## Kurri Kurri Lateral Pipeline Project update

APA Group is pleased to provide an update on the Kurri Kurri Lateral Pipeline Project (KKLP – the Project).

## Attachment 1 – Design refinements

Compressor Station, Delivery and  
Associated Laydown Areas

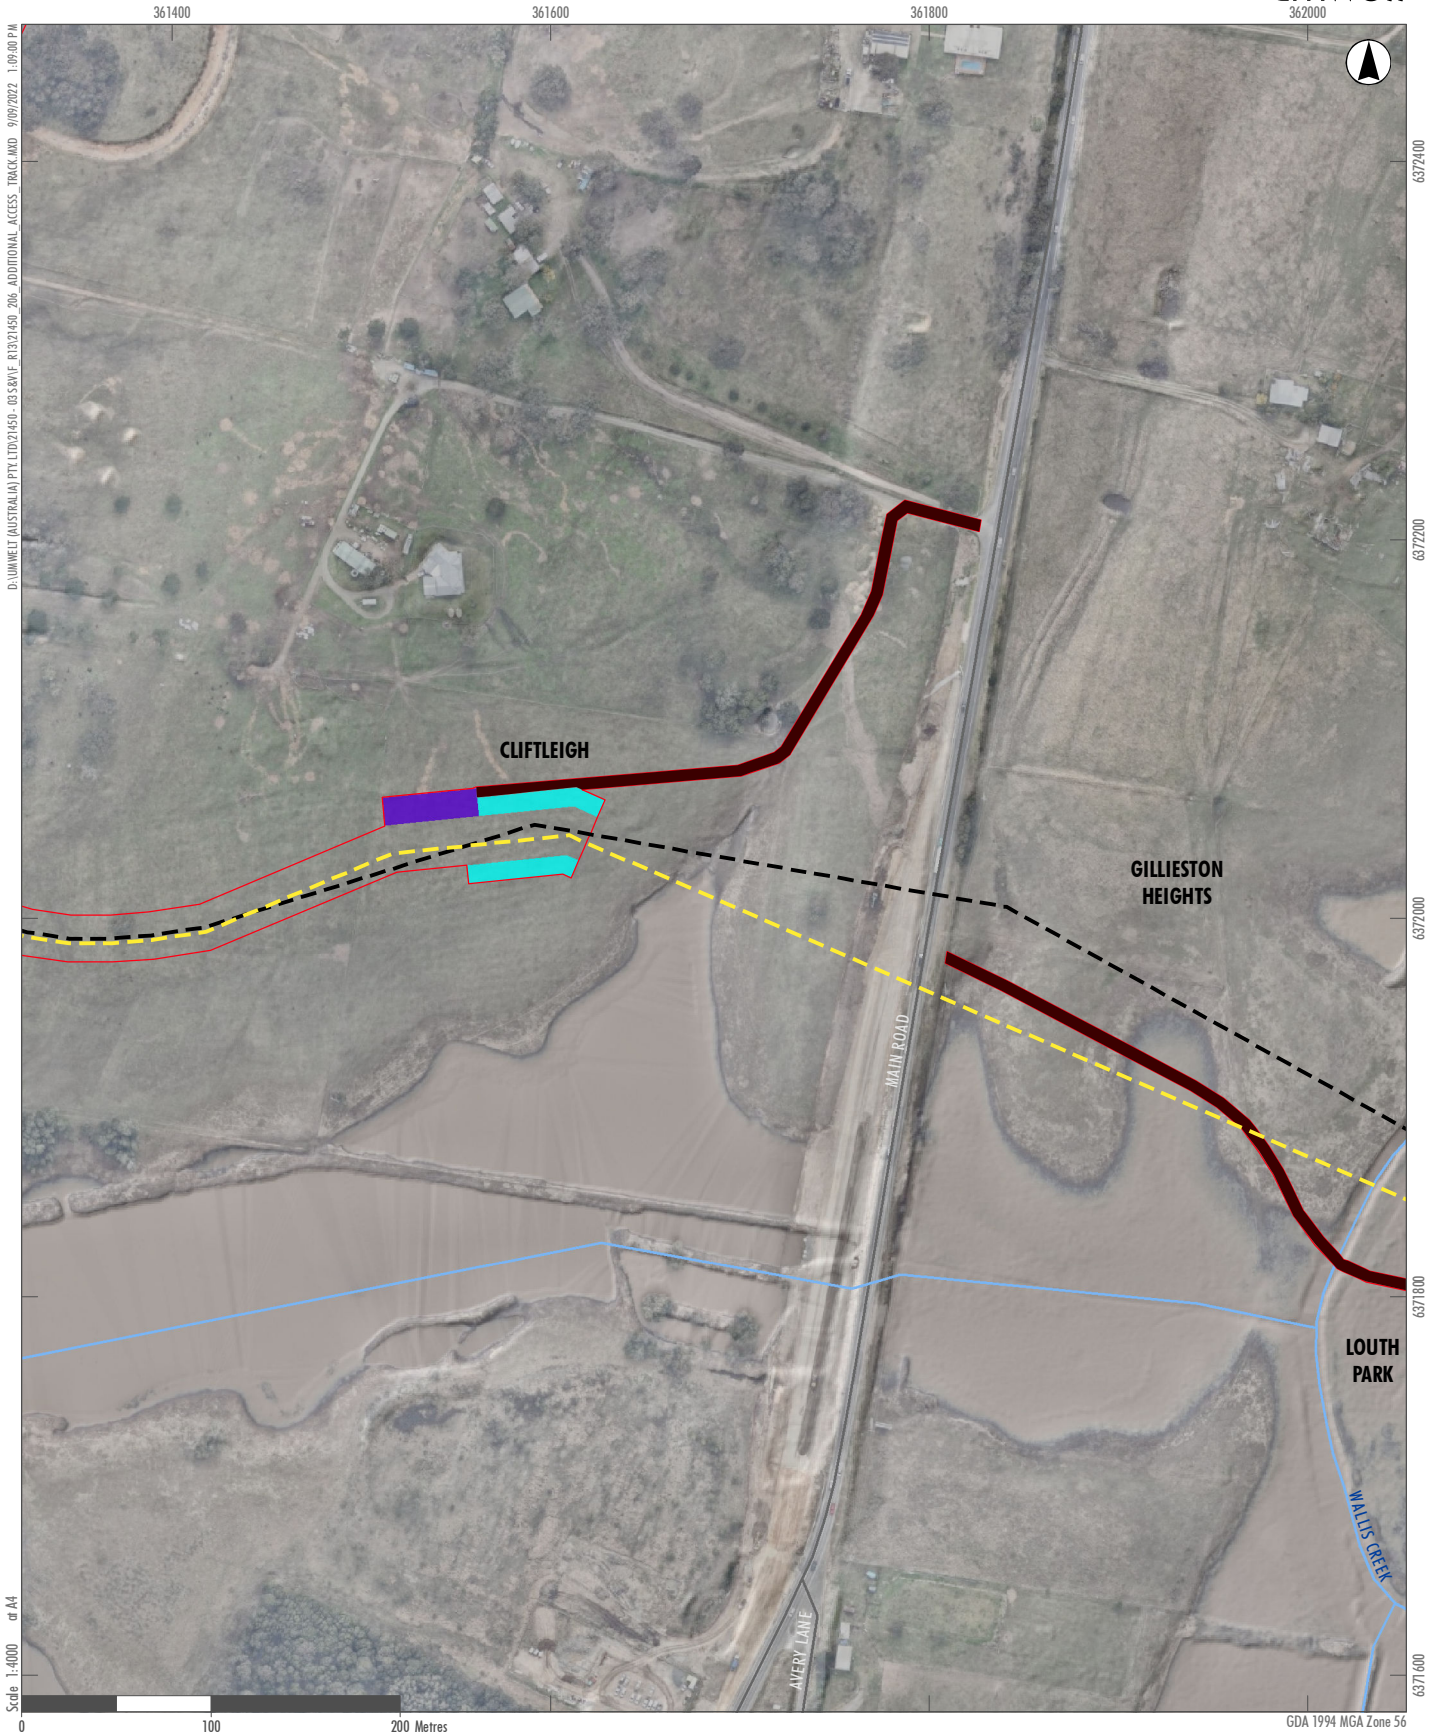
The southern boundary of the compressor station and delivery station footprint has been extended approximately 50m to the south to align with southern extent of the HPP 'proposal site'. This also aligns with the boundaries of the proposed Lot 2 DP 1276814, as part of the Regrowth Kurri Kurri project. This increases the area of the footprint by around 0.75ha. There are no material changes to environmental impacts assessed in the EIS given the site is hardstand that has been used for industrial activities for many decades. The additional area remains subject to remediation required to be undertaken as part of the Hydro Aluminium project (SSD-6666).

Discussion have further progressed with these parties and laydown areas have been rearranged. The laydown area east of Harts Road within the former carpark of the smelter has been removed and the laydown area west of Harts Road has been extended.

Main Road to Construction Footprint

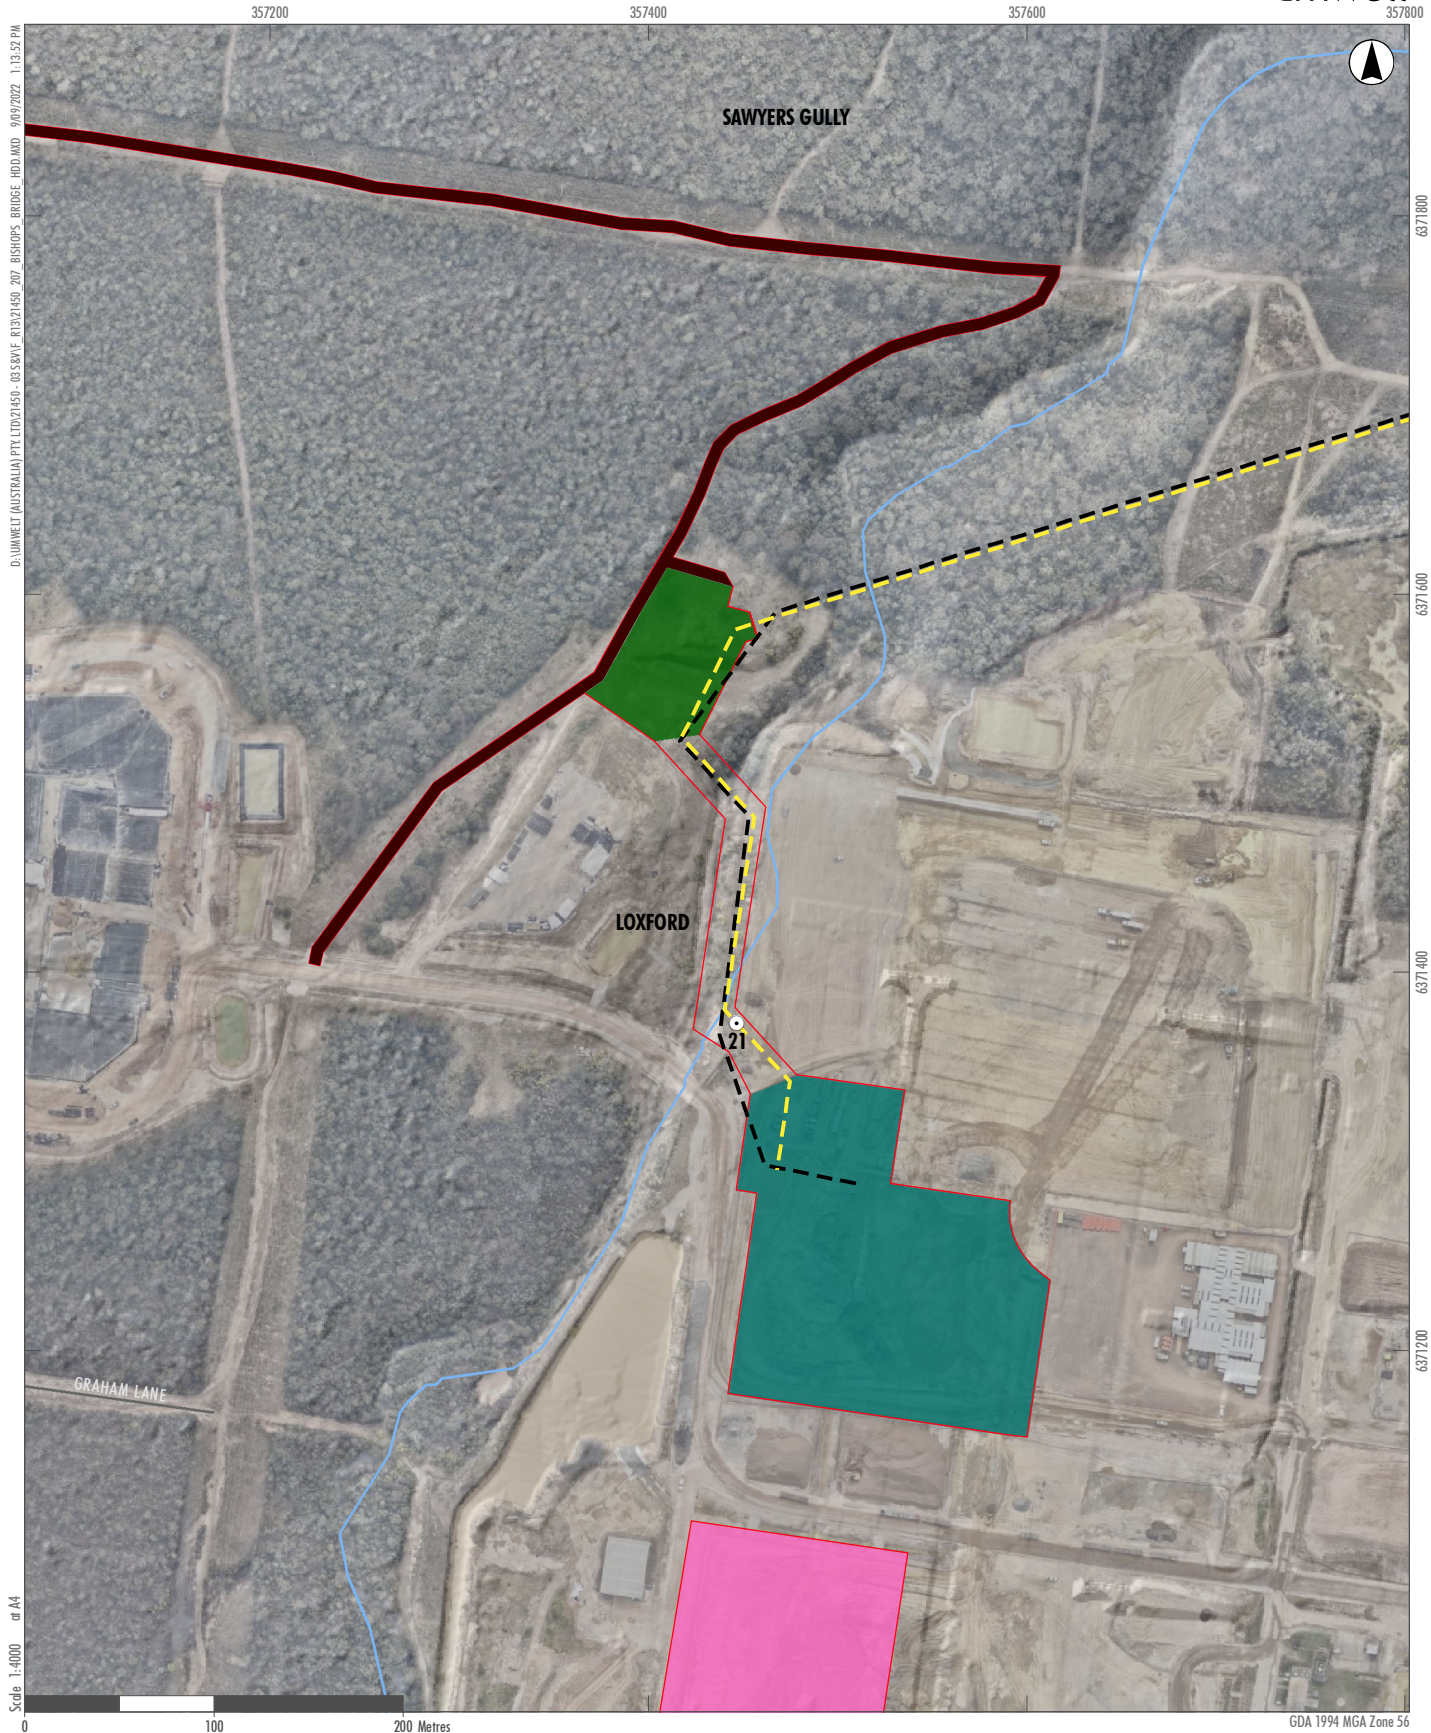
Main Road to construction footprint - A track of 350m length following an existing farm track through a cleared paddock on Lot 2 DP1249763 on the western side of Main Road. Previously a crossing of Main Road was proposed adjacent to the horizontal bore of the road. The horizontal bore has been replaced by a HDD from the western side of Main Road to the eastern side of Wallis Creek, which enables an

area of known ASS to be avoided and trenching disturbance to the Wallis Creek floodplain to be reduced. A track is required to access the HDD workspace.
